RE: Lindfield Learning Village, 100 Eton Road, Lindfield (SSD-81146) (KU-RING-GAI COUNCIL) – Response to Submissions

Heritage Council (HC) comments on the proposed Phase 2 and 3 development SSD 8114– External Works:

Figure 6 – Revised SSD proposal showing rooftop additions omitted from revised scheme.

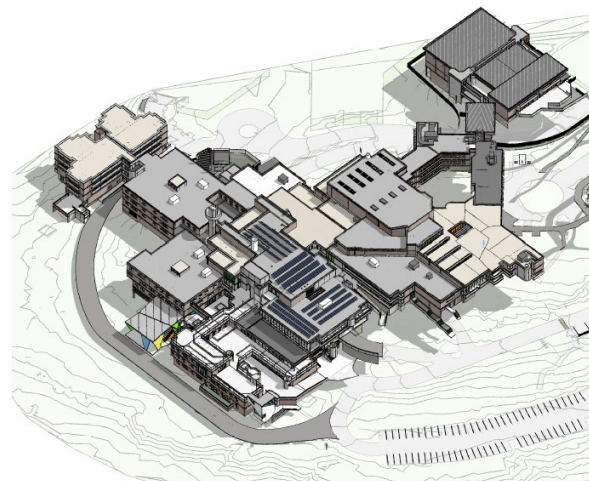
1. *The omission of rooftop additions*
The omission of new rooftop structures retains the existing stepped and modulated building form and is consistent with the CMP (Policy 36). The proposed modification retains the significance of the Sydney Style building and its setting and is supported.

Figure 9 – Proposed demolition plan showing removal of the link and planter.

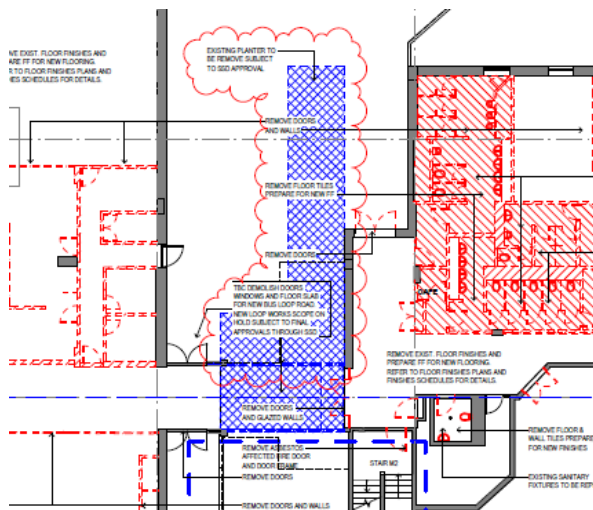
3. *Partial demolition of link between stages 1 and 5 for link road*
The ground floor of the link between Stages 1 and 5 of the building, graded as moderate significance, is proposed to be demolished to enable the new loop road to pass through to the rear of the building. The bulk of the ground floor section to be demolished comprises large areas of anodised glazing that is attributed little significance in the CMP. The removal of the planter box and service area adjacent to the link removes part of the original landscape design recommended to be retained (Policy 44 CMP) however as a service/courtyard area it is assessed as of lesser significance. The partial demolition of the link would have some heritage impact on the

heritage values however it can be supported as the retention of the first floor enables the original configuration to be interpreted and the requires less tree removal than the alternative via the western side of the Stage 5 building.

Figure 11 – General layout of sandstone logs.

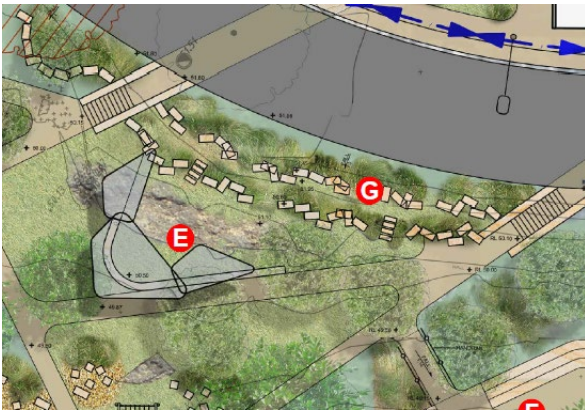
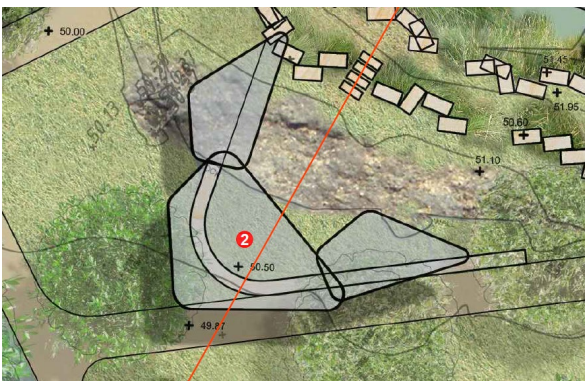
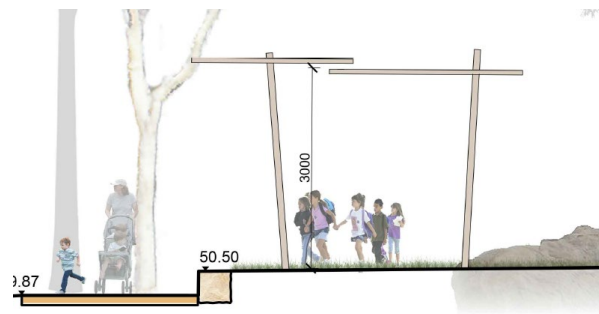
The proposed landscape works to the southern section of the site seek to mitigate the intrusion of the link road while introducing a variety of landscape treatments for useable play spaces. Whilst the proposed landscape materials, limited use of turf and retained pockets of indigenous vegetation are sympathetic to the natural bushland setting, the formality of the paths and spaces that extend to the site boundary fail to reflect the forms and features of the natural topography.

This is considered inconsistent with the landscape philosophy of Bruce Mackenzie, the original landscape architect, that maintained, '*existing contours, rocks and trees can be the main determinants of composition*', emphasising the importance of the '*often-subtle juxtapositions between built elements and soft landscaping and remnant bushland on the site*' (CityPlan Heritage 2004).

- It is recommended that as for Phase 1, a condition of consent be included requiring that the landscape works in the southern section of the site be finalised in consultation with Bruce Mackenzie to ensure a sympathetic approach in accordance with the landscape philosophy.

Figure 20 – Proposed demolition to southern façade.

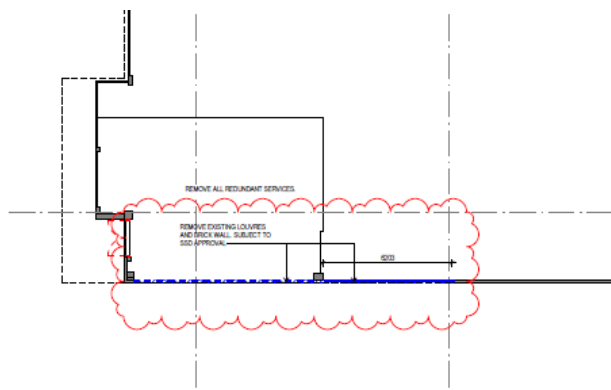
The removal of an area of louvres and a small section of brick wall to the south façade, graded high significance, is proposed. The anodised windows are graded of little significance and as they are not part of a fenestration pattern, their removal is consistent with the CMP fenestration policy. However, the removal of brickwork to slightly enlarge the opening is irreversible and will remove significant fabric.

- It is recommended that a condition of consent be included requiring that an alternative fenestration design is recommended for the South Façade Level 1 to ensure that the existing masonry wall is preserved intact.

Figure 23 – Revised SSD proposal showing revised COLA design.

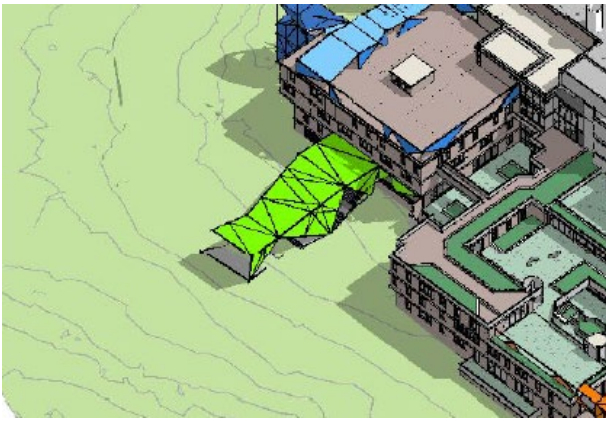
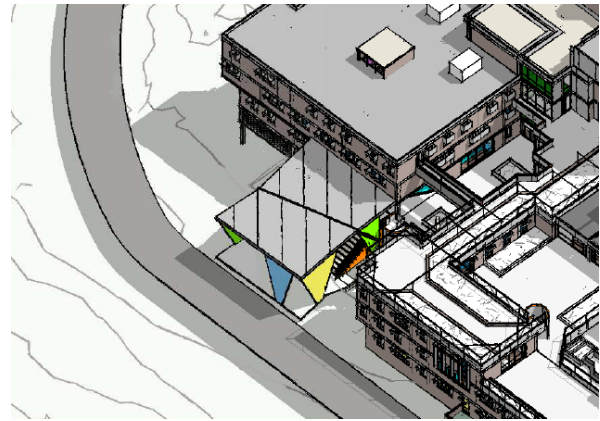
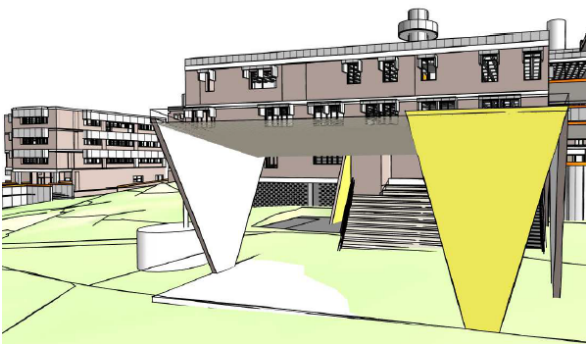
8. *Alterations to COLA*
The proposed COLA has been reduced in length and is wider than the original design. The height remains below the exposed slab of Level 3 and there is no impact on the spiral stairs to the east of the COLA, consistent with the original design. The design is consistent with the CMP and can be supported.

Figure 30 – Proposed stair risers.
Source: Lacoste Stevenson

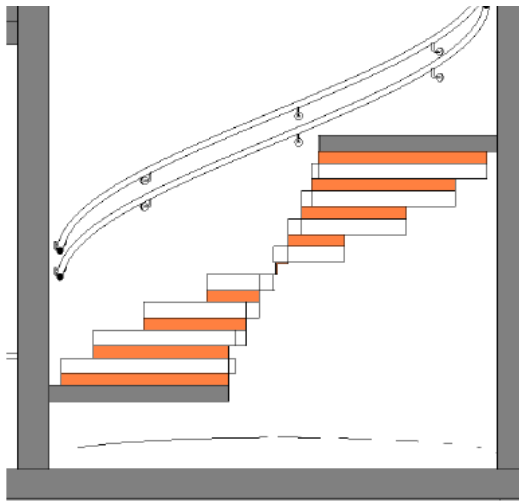
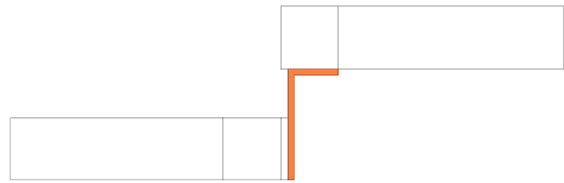
11. *Spiral stairs*
The spiral stairs through the building are proposed to be modified for compliance. Modifications to the handrail position and the insertion of a riser ensure the treads and risers are compliant. The proposed pink handrails and orange risers are in keeping with the original contemporary overlay applied in Phase 1 and can be supported.

Figure 33 – Section of concrete wall to be removed shown shaded pink.

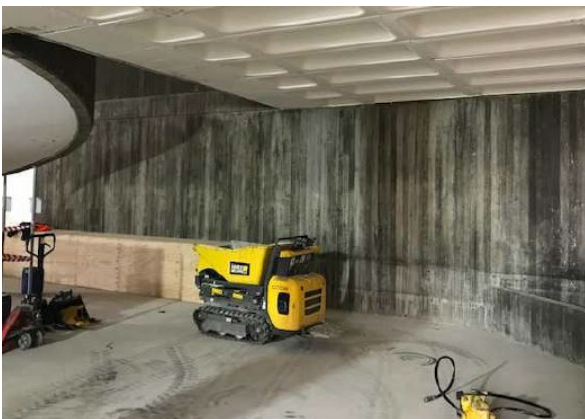
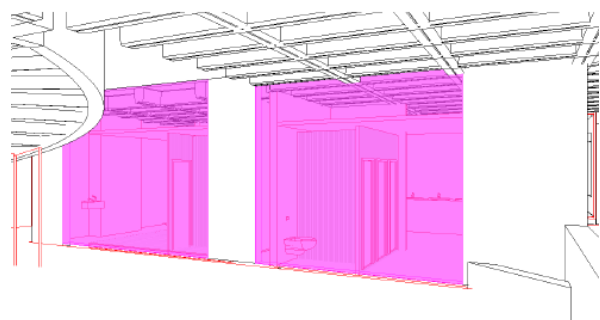
12. *Removal of concrete wall adjacent to spiral stair*
The proposed removal of two portions of concrete wall (3853mm wide and 3376mm wide x 2700mm high) for increased light penetration will require the removal of a substantial amount of original fabric, identified in the CMP as of high significance. The removal of a substantial area of the existing concrete wall adjacent to the spiral stair will have an irreversible physical and visual impact on the significance of the item.

- It is recommended that a condition of consent be included requiring that an alternative light source is designed to ensure significant fabric and views are preserved intact.

Figure 34 – Wall to partly be demolished.

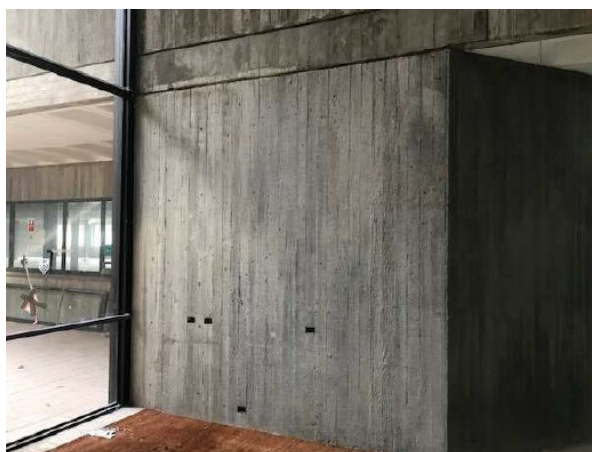
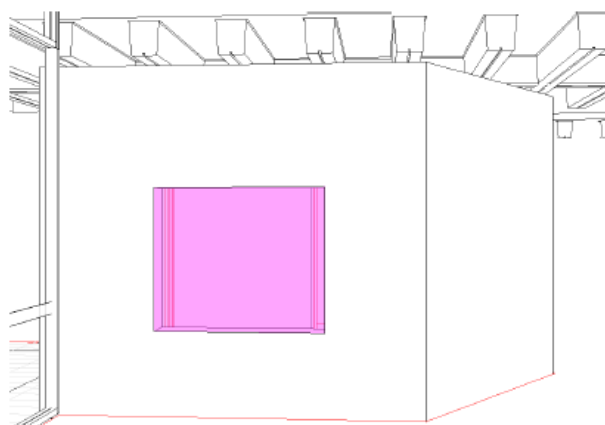
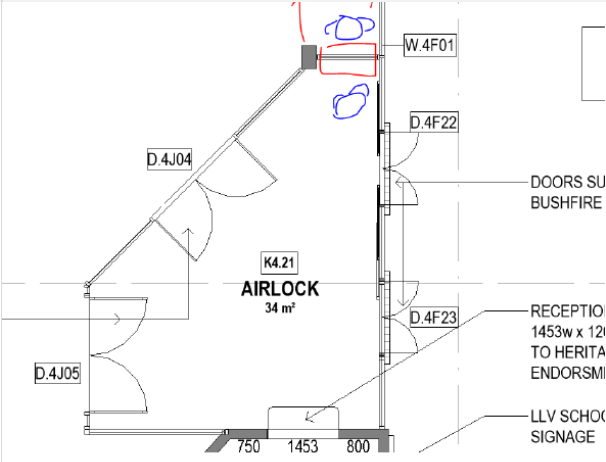
13. *Removal of concrete on level 4 to allow for reception window*
The proposed creation of an opening within the concrete element of the of the Level 4 Main Entry for the reception will require the removal of visually prominent original fabric, identified in the CMP as of high significance. None of the five options provided avoid the demolition of a section of this visually prominent concrete wall. This is inconsistent with the CMP (Policy 27) and with a previous condition of consent (B34) that require new works to be designed as reversible. The removal of a section of the concrete wall adjacent to the Level 4 entry, will have an irreversible physical and visual impact on the significance of the item.

- It is recommended that a condition of consent be included requiring that an alternative location for the reception is found to ensure that the Stage 1 and 2 off form concrete walls and the existing visual connections between floors, are preserved intact
